**From:** Christopher Fraser <Christopher.Fraser@planning.nsw.gov.au>  
**Sent:** Monday, 31 May 2021 9:54 AM  
**To:** Grant Harlow  
**Subject:** S29/3/97-Mod-1 - Eastern Creek Karts, Departments design comments  
**Attachments:** Endeavour Energy.pdf

Following on from our discussions on design requirements on 26<sup>th</sup> and 28<sup>th</sup> May 2021 for the above please see the following notes for design work ;-

TITLE:
SITE PLAN

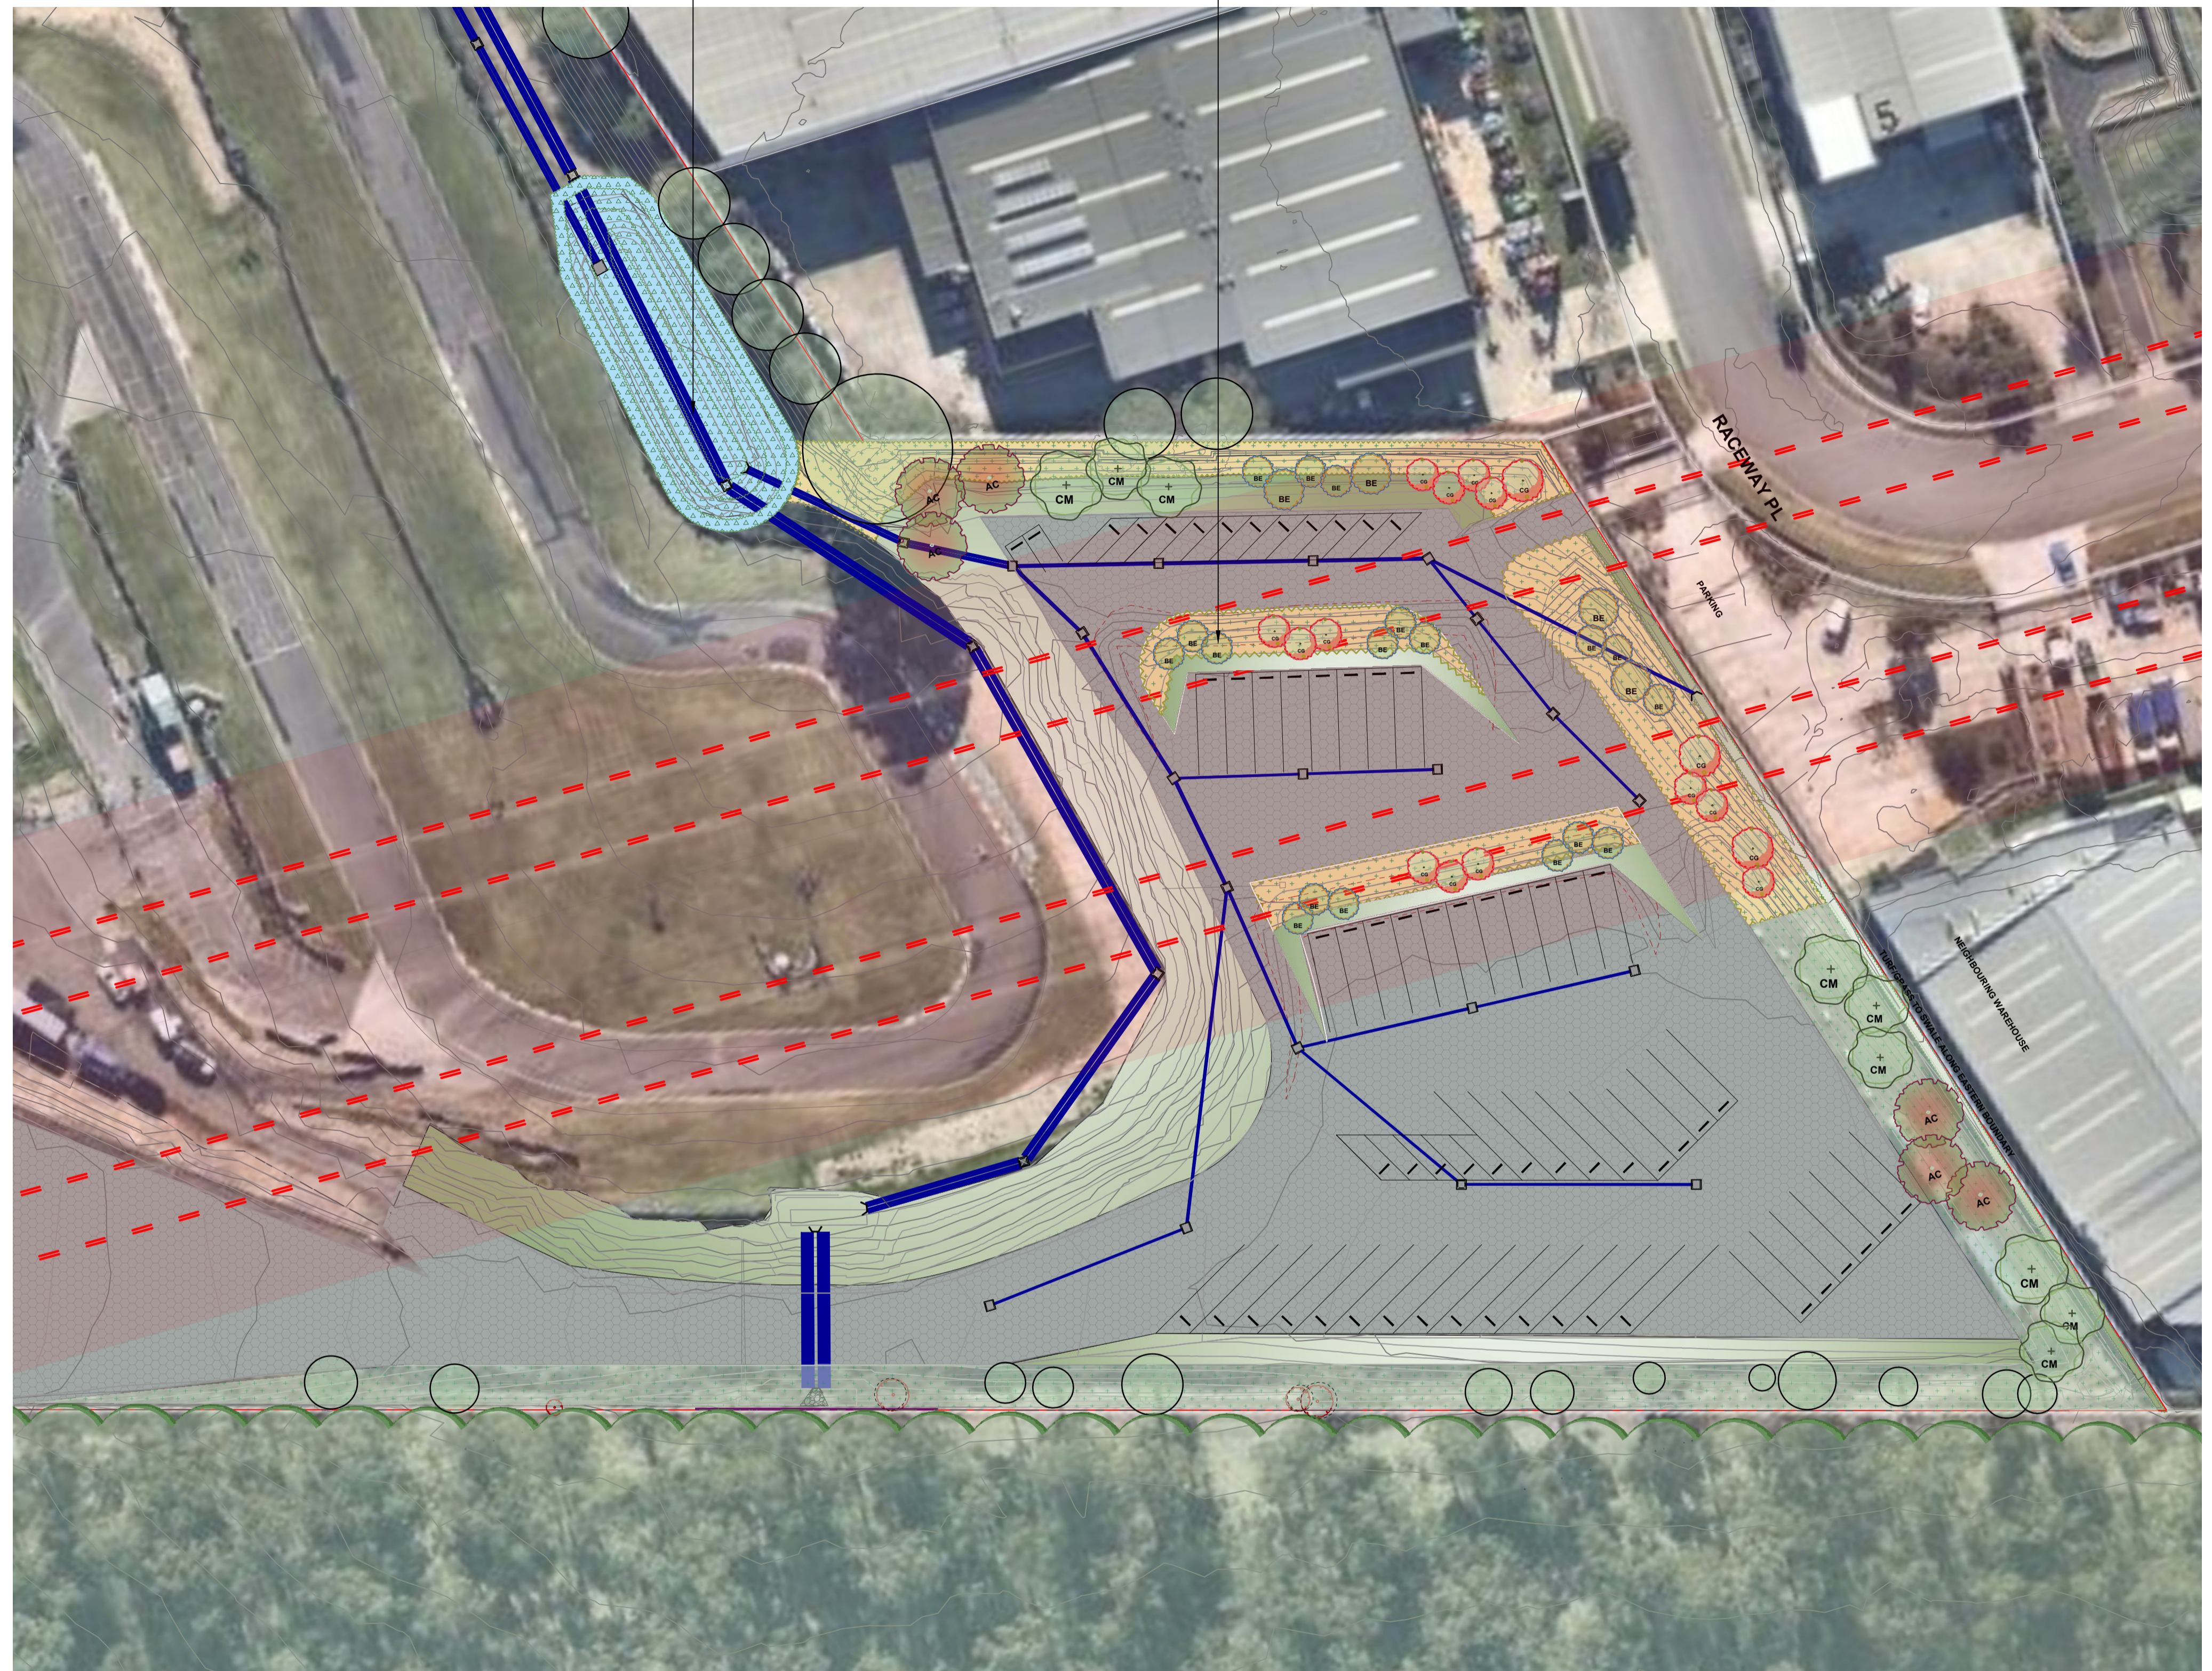
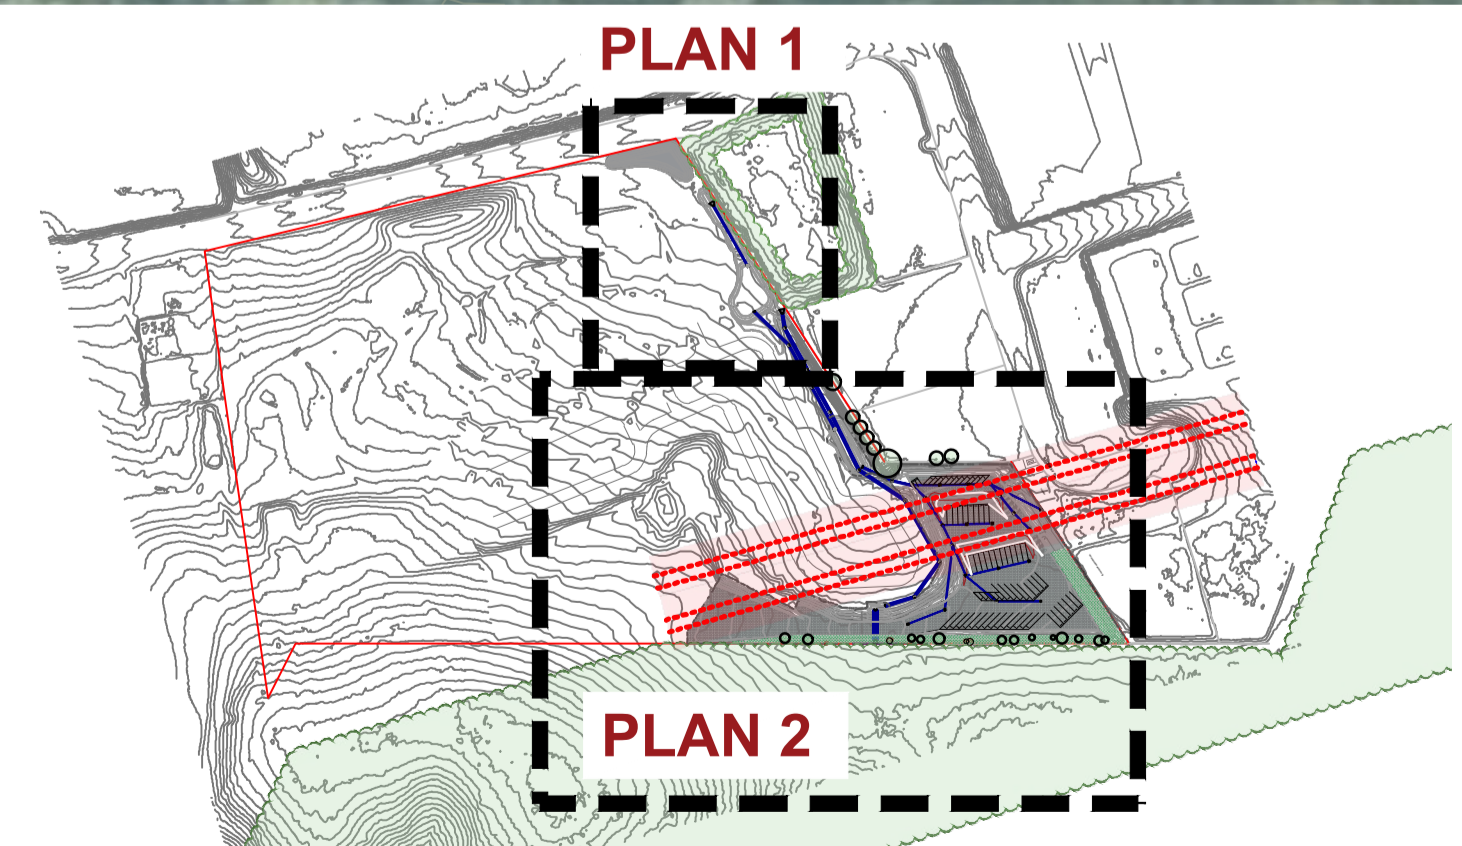
9. Design matters in Dept. letter 13 May Sections 3, 4 and 5 appear not contentious.
10. Landscaping is emerging as necessary to reduce visual impact on the fill work, though subsequent to final drainage and carpark design. Allowance should be made for paving, kerbing and AS 2890 -compliant safety railing.

11. The landscape professional may consider locating trees, if they assist in reducing visual impacts, away from paving, safety devices and batters. Please provide more detailed landscape plans.
